RE: ALLSHIPS - 4TH & BELLAHAI DRAINAGE REPORT

RE: ALLSUP SITE - 4TH AND BELLAMAH DRAINAGE REPORT

A review of the referenced report has resulted in the comments listed below. The numbers indicated refer to the Drainage Report (DR) and Construction Plan (CP) checklists.

VICINITY MAP-J-14

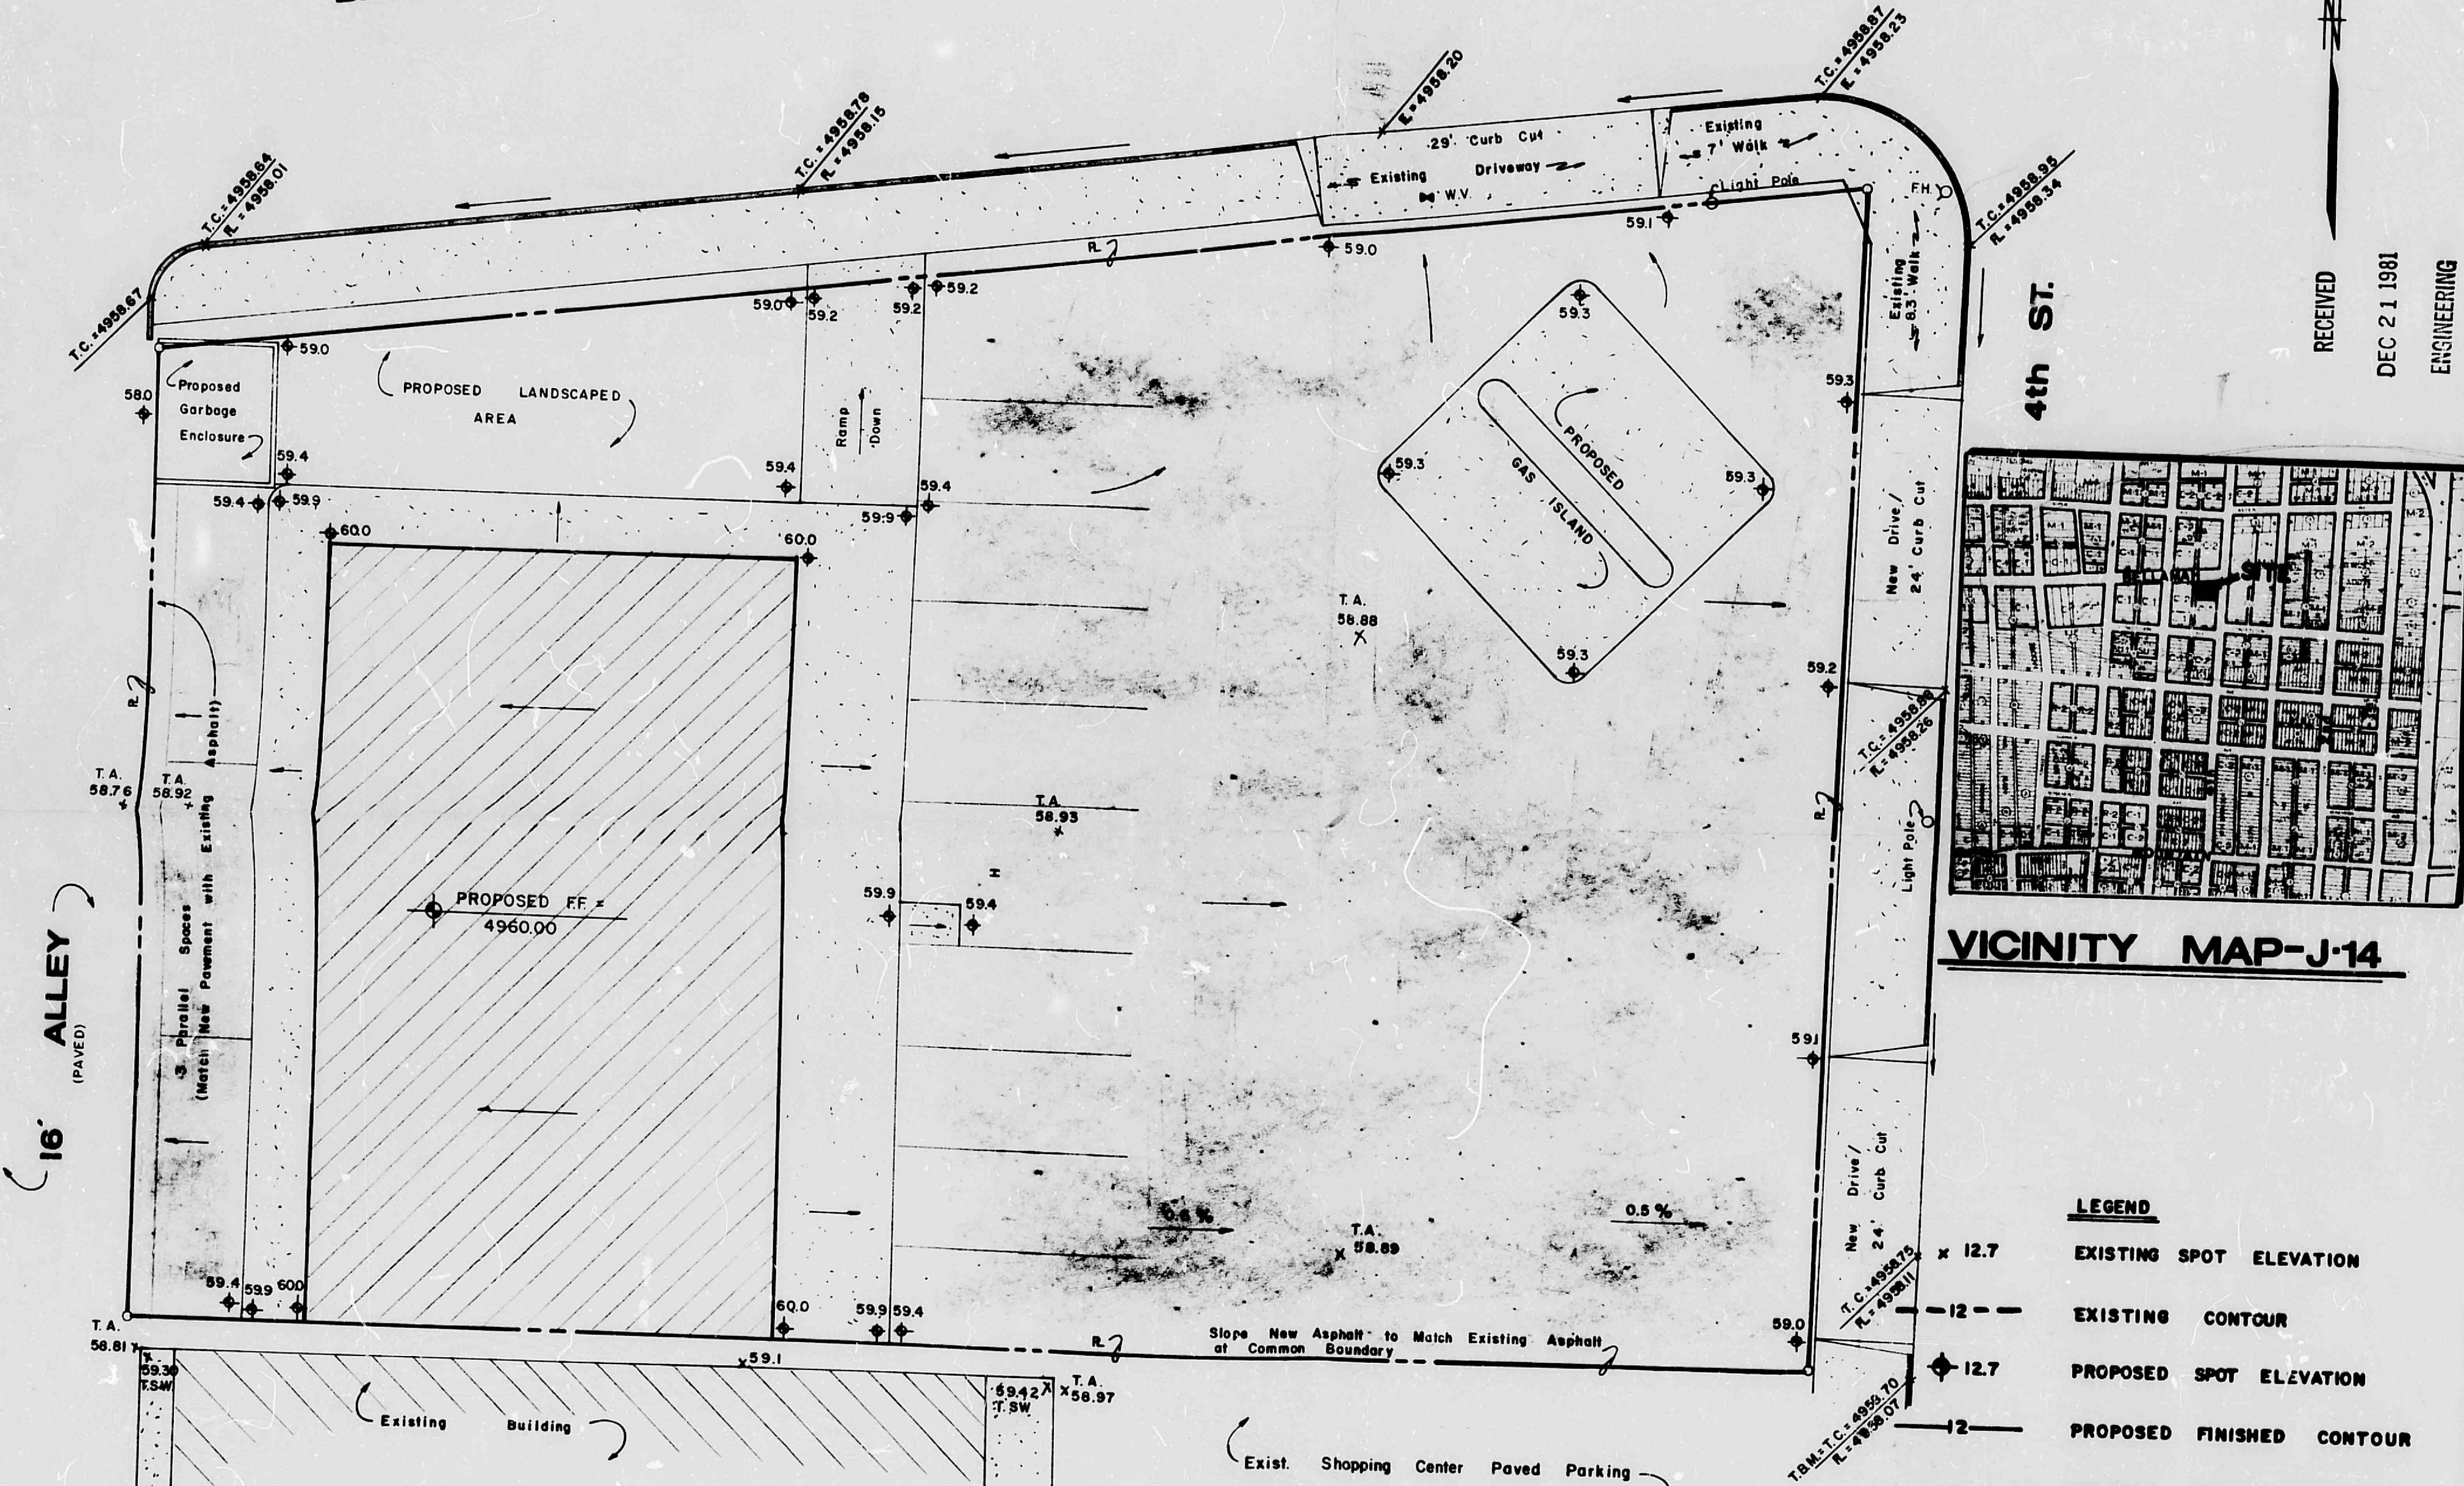
1. DR # 4 - The pertinent flood hazard boundary map should be supplied to indicate how the finish floor elevation was determined.
2. DR # 10 - Does the adjacent building contribute any runoff to the site? (i.e., through drainpipes, etc.)
3. Please provide a completed copy of the Drainage Report Information Sheet.
